Planning Consultation Memo

Date	Planning Officer	Environmental Health Officer
25/11/2021	Ms Louise Sahlke	Terry Vincent
Planning Application Number	Worksheet Number	
6/2021/3194/COND	WK127963

Address: 26 Stonehills Welwyn Garden City AL8 6NA

Application Details: Submission of details pursuant to condition 2 (traffic and commercial/industrial noise) on planning application 6/2019/1452/MAJ

Appendix A: Site Plan – measurement positions ●

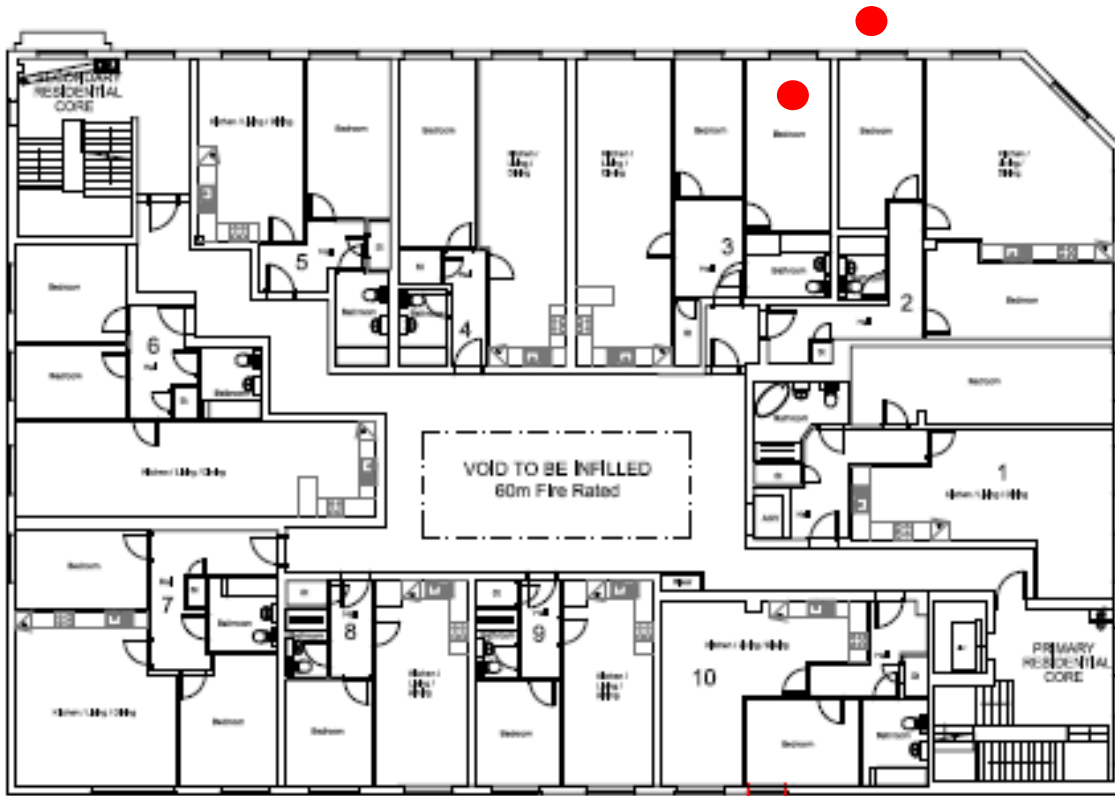
The internal measurement location plan in appendix A is unreadable. Therefore, I cannot tell which room was used for the measurements. It is also important to note that internal noise measurements must be taken within representative rooms inside the building. Therefore, measurements must be taken within a bedroom and a living room. According to the plan, measurements were taken in one room only, which is not correct. Noise levels should also be taken on the façade that looks onto Stonehills.
